RailCorp Property
PO Box K349
Haymarket NSW 1238
Tel: (02) 8922 4062 Fax: (02) 8922 4890
Email: alexandra.stathakis@railcorp.nsw.gov.au

22 June 2011

PROJECT APPLICATION – MP08_0043 MOD 1
Honeysuckle Central, Lot 25 Honeysuckle Drive, Newcastle

Project Honeysuckle Central Honeysuckle Drive Newcastle NSW	Drawing Sections
Client Builddev / Eureka Funds Management	Scale 1:250 @ A1 / 1:500 @ A3
	Date 01.10.08
	Drawn MH/CS/EH
	File Name I:\10000\10200\10299\0-Base\10299_model.pln
	Project Number 10299
	Drawing Number DA16
	Issue F

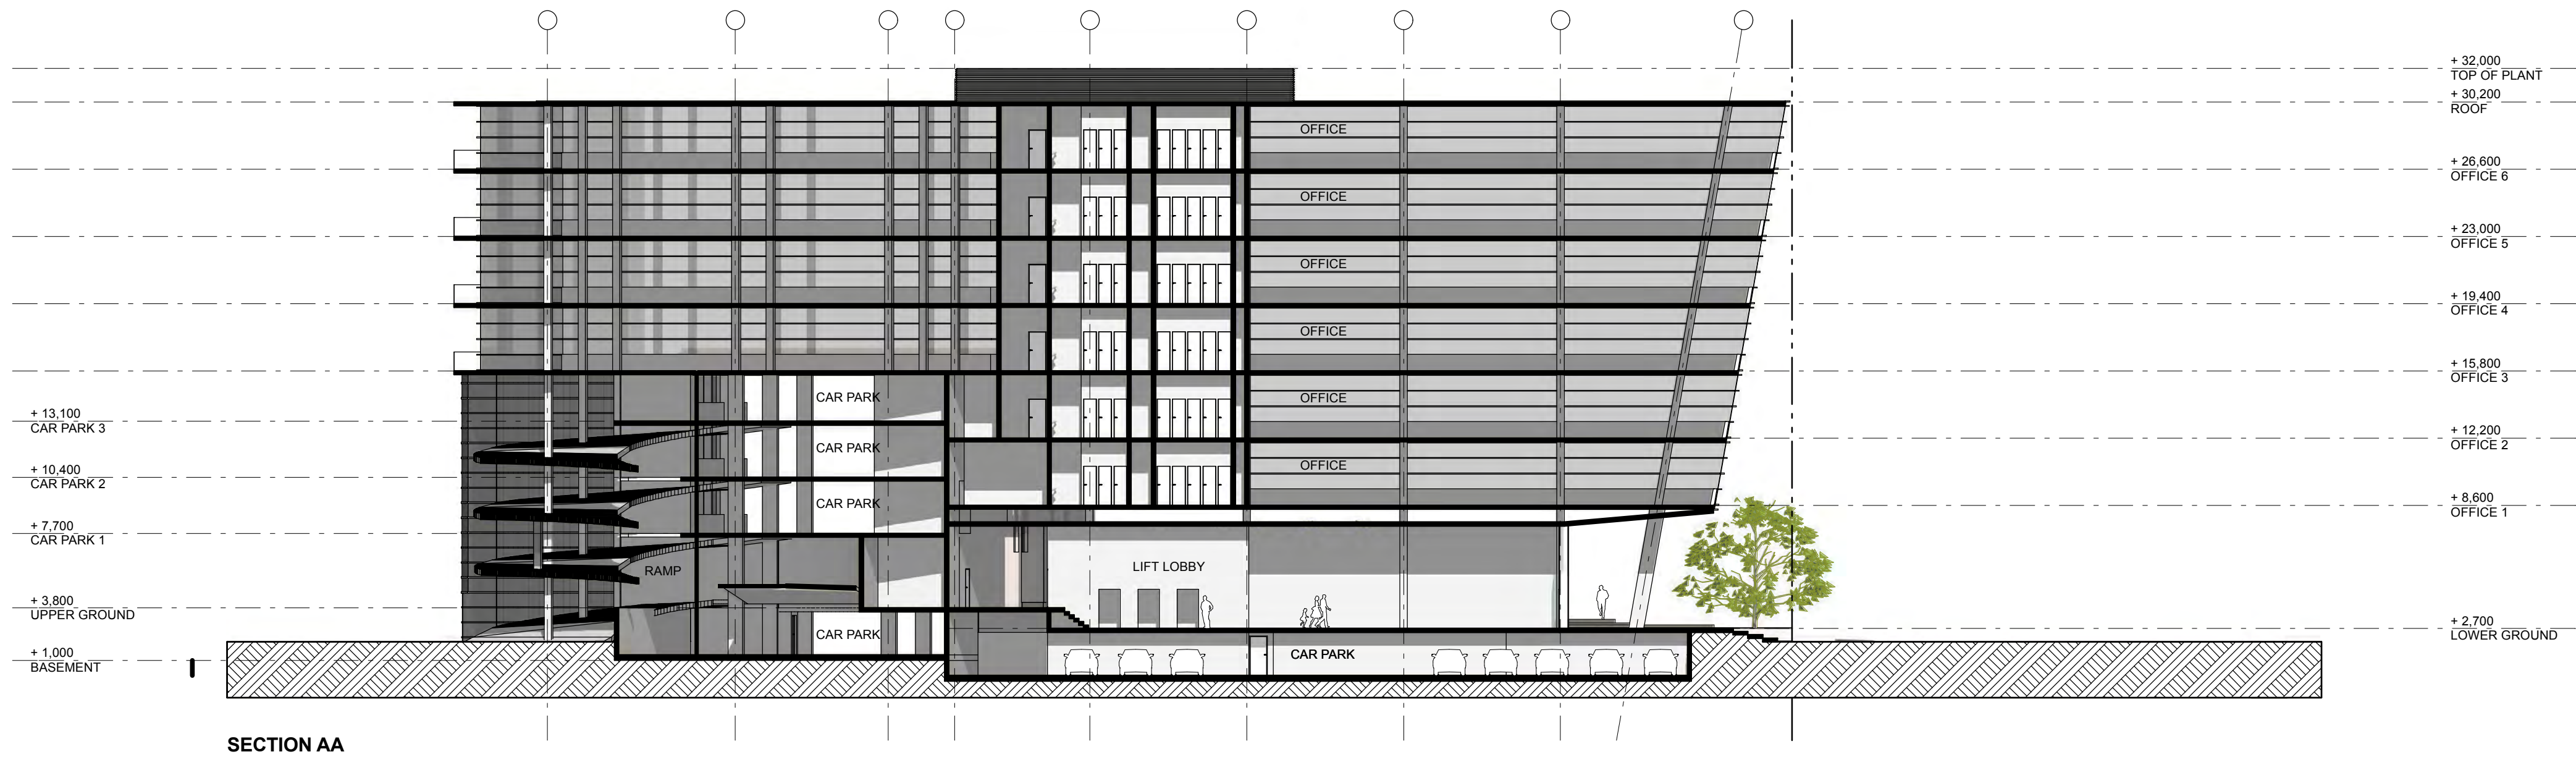
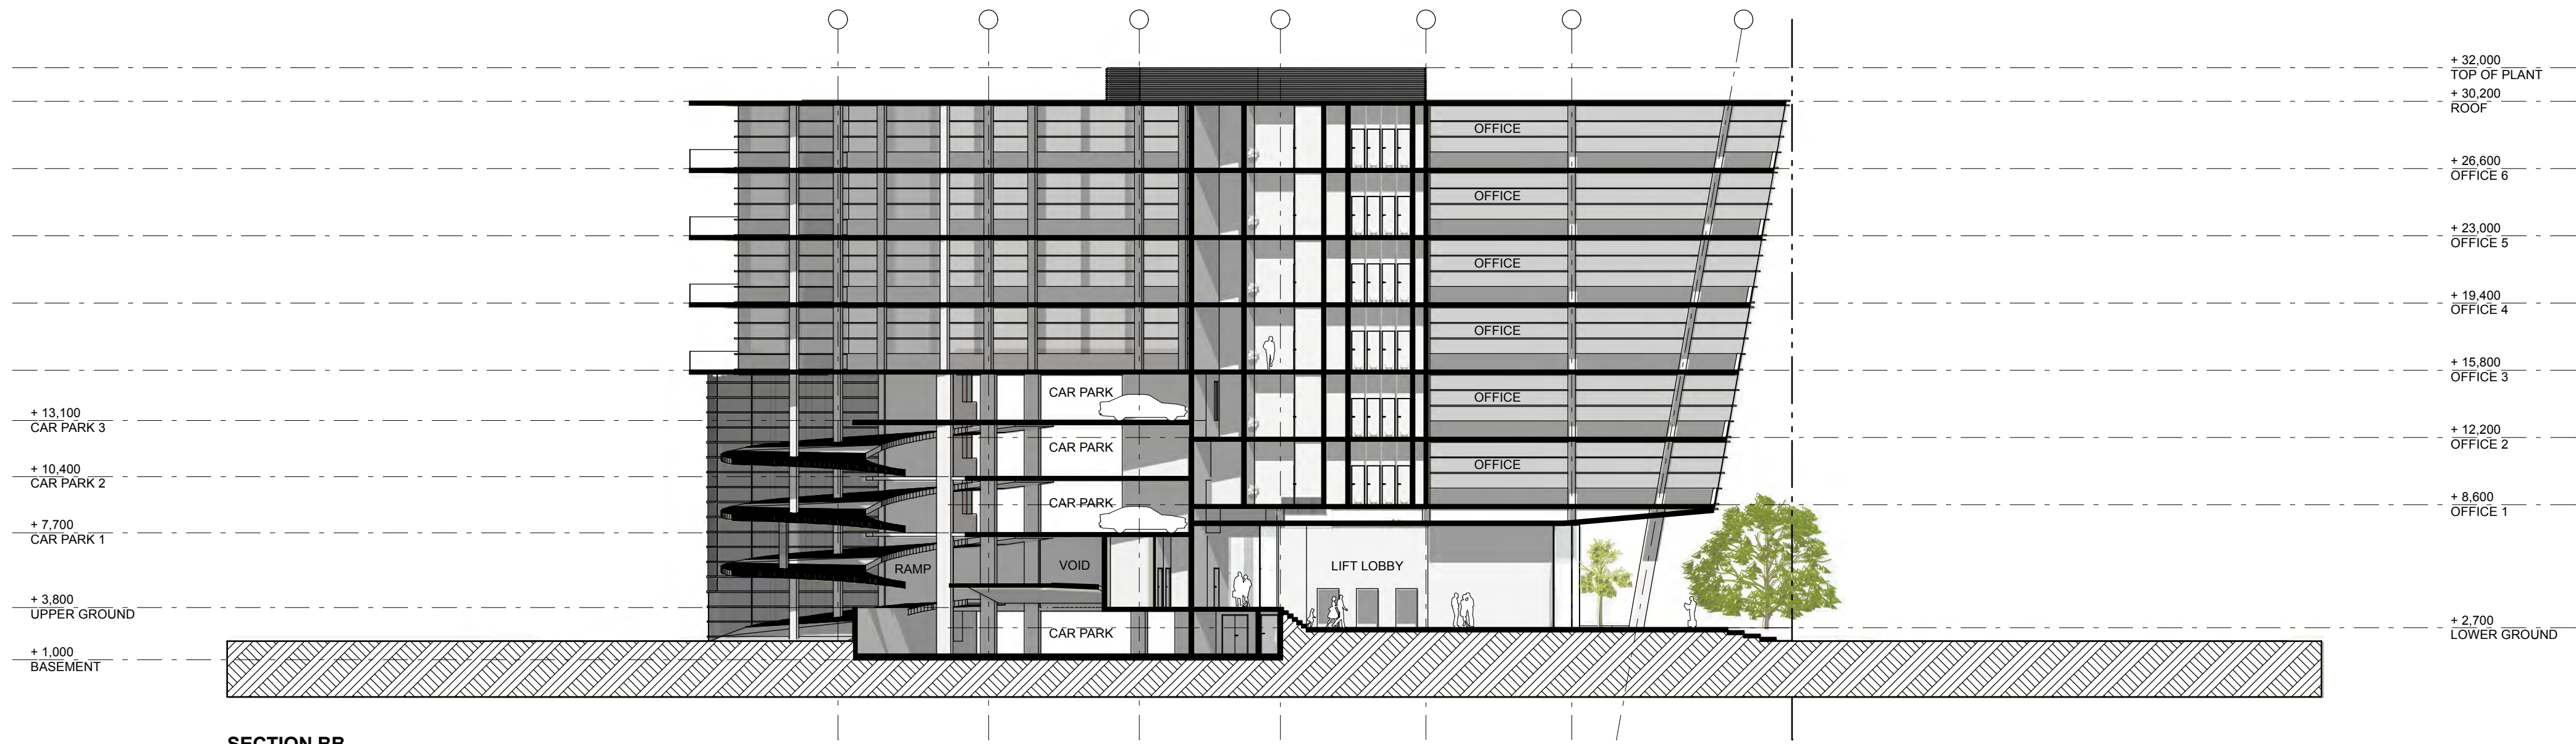
RailCorp requests that the applicant provide Cross sectional drawings showing ground surface, rail tracks, sub soil profile, proposed basement excavation and structural design of sub ground support adjacent to the Rail Corridor. All distances measured from the rail corridor and rail infrastructure are to be confirmed as accurate by a Registered Surveyor.
